Application Ref:	3/2025/0804			 Ribble Valley Borough Council www.ribblevalley.gov.uk
Date Inspected:	30/10/2025	Site Notice:	N/A	
Officer:	MC			
DELEGATED ITEM FILE REPORT:				REFUSAL

Development Description:	Certificate of lawfulness for the proposed use of a (Use Class C3a) dwelling house to a children's home (Use Class C3b)
Site Address/Location:	36 Moor Field, Whalley, BB7 9SA

Figure 2: NB25_18-03A pr plans 50-A1

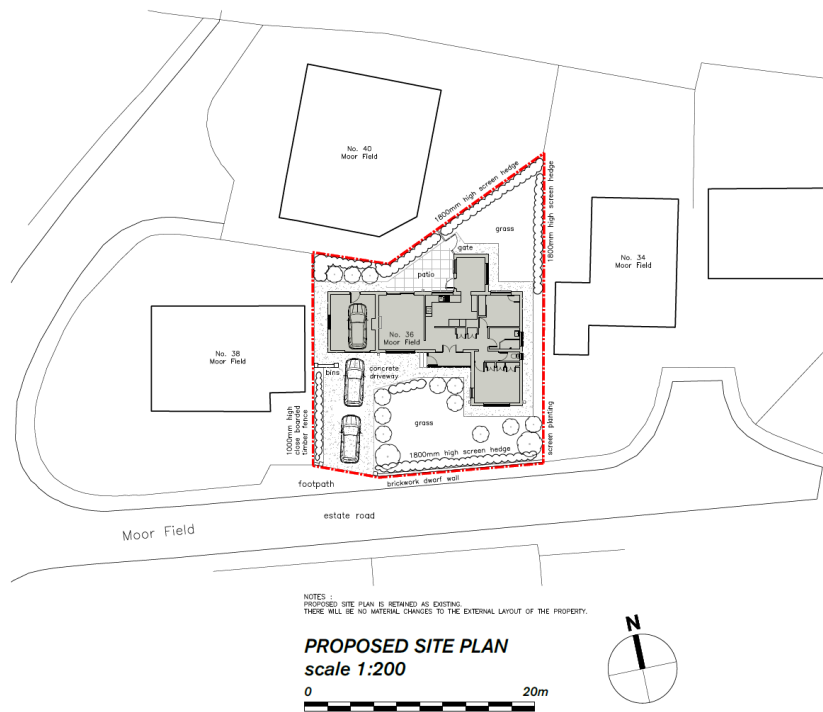
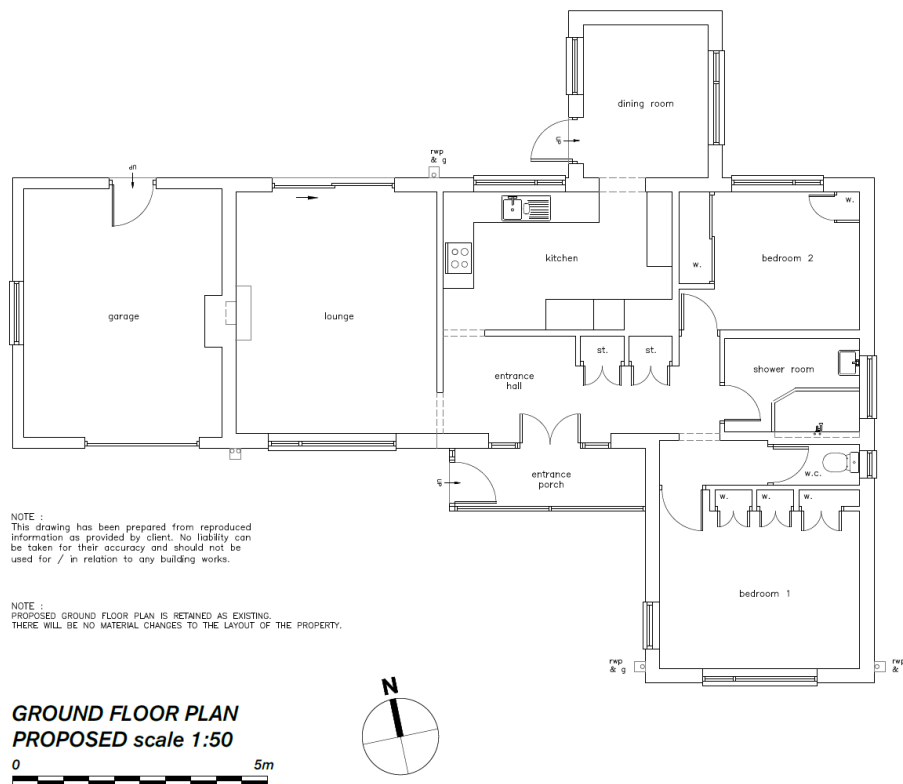
The supporting information indicates that there are 3 no. parking spaces at the property with 1 no. parking space within the existing garage as indicated on the submitted drawings.

It is noted that the internal dimensions of the garage parking space is approximately 5.05m x 3.9m and the minimum internal size of a garage for it to be counted as a parking space would be 6m x 3m. As such, the garage cannot be counted as a parking space, meaning there would be 2 off street parking spaces.
